Ribble Valley Borough Council
Council Offices
Church Walk,
Clitheroe
Lancashire
BB7 2RA

Phone: 0300 123 6780
Email: developeras@lancashire.gov.uk
Your ref: 3/2025/0997
Our ref: 3/2025/0997/HDC/KW
Date: 27 February 2026

Location: Land off Henthorn Road Clitheroe BB7 3BY
Proposal: Outline application for the erection of up to 115 dwellings, including affordable housing, with public open space, landscaping, sustainable urban drainage system (SuDS) and vehicular access. All matters reserved except for means of access.
Grid Ref: 372961 440676

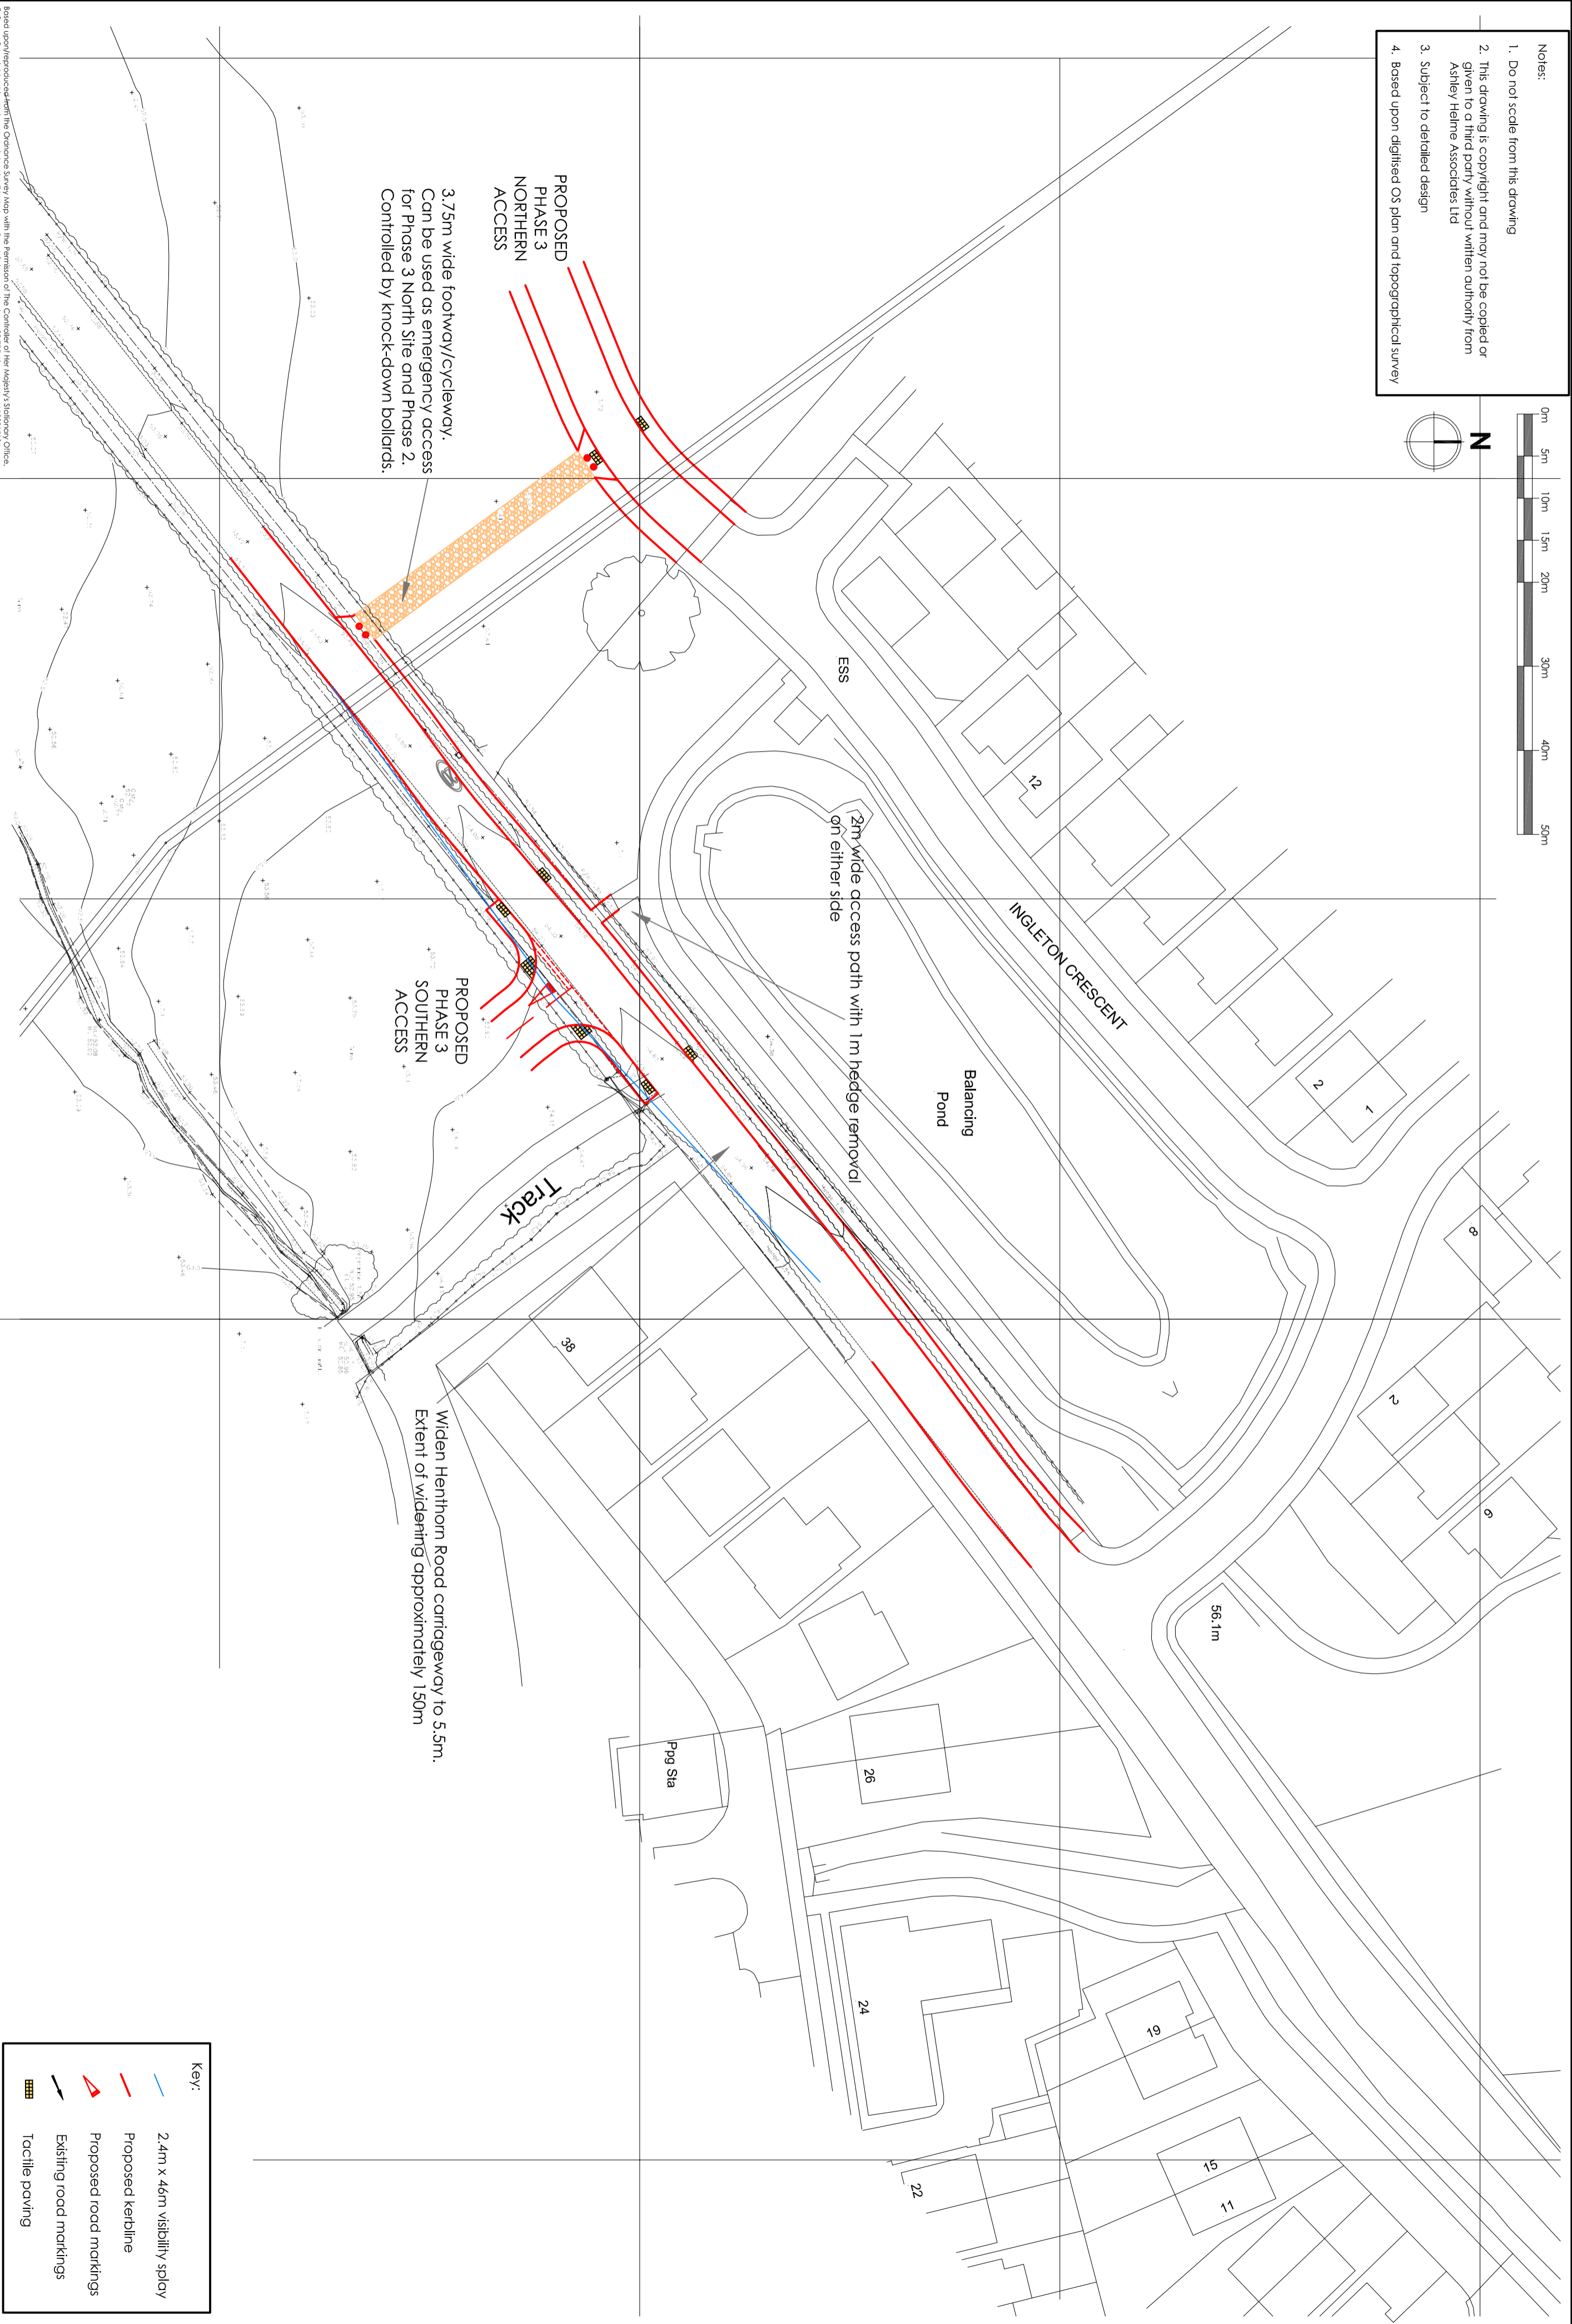
A secondary emergency access arrangement is also provided within drawing number 1677/01, revision F, to provide access to the development which sits to the north of Henthorn Road, as well as serving as an emergency access to the Phase 2 development. The emergency access is 3.75m wide and controlled by knock-down bollards positioned on both sides. The access will require a visibility splay of 2.4m by 46m (based upon recorded speeds) in both directions; this will be achievable within the site boundary and over the newly adopted footway provisions.

On the north side of Henthorn Road, a new footway is proposed that will connect into the existing footway at the junction with Waterfall Gardens. A new footway is proposed for approximately 140m in the other direction until it meets the proposed secondary emergency access arrangement, where it terminates.

However, given the 85th percentile speeds, (32.4 mph Northbound and 32.5mph Southbound) recorded for the visibility splays, at which vehicles travel along Henthorn Road there are pedestrian safety concerns due to the lack of footway provision beyond what is currently proposed. Shared space arrangements are only recommended where vehicle speeds and flows are very low. Given the intensification of vehicle and pedestrian movements, the LHA require 2m footway provisions to be provided along the North side of the entire site frontage up to the private access road, named Ribble Way, within the

Drawing number 1677/01, Revision F also includes the access arrangements for the proposed development, which sits to the South of Henthorn Road. The proposed access measures 5.5m for 10m behind the carriageway edge, with 2m footway provision on either side.

As such, the applicant has provided visibility splays at the southern site access with Henthorn Road of 2.4m by 46m in both directions. It is understood that the applicant has offset the visibility splay to the right by 1m, however the LHA is of the opinion that the verge forms part of the adopted highway and, as such, the visibility splay should remain within the highway or the applicant's site without being offset. We ask that this be amended.

It is understood that Henthorn Road is to be widened by approximately 1.5m to 5.5m wide, which will support 2-way vehicle movement. There are also existing field gate access points, which should be permanently closed should approval be granted.

- Localised widening of Henthorn Road to a minimum of 5.5m
- Provision of a 2m footway along the northern side of Henthorn Road for the full extent of Henthorn Road.
- Street lighting provisions along the North side of Henthorn Road.
- Provision of a 2m footway along the southern side of Henthorn Road for approximately 6m to the left and 8m to the right
- Pedestrian crossing facilities on both sides of Henthorn Road provided on either side of the
- A traffic calming scheme comprising of signing and road markings on Henthorn Road.
- Highway Drainage along Henthorn Road, which falls into an internal outfall within the wider site.
- Access arrangements for the Public Right of Way terminal points onto Henthorn Road
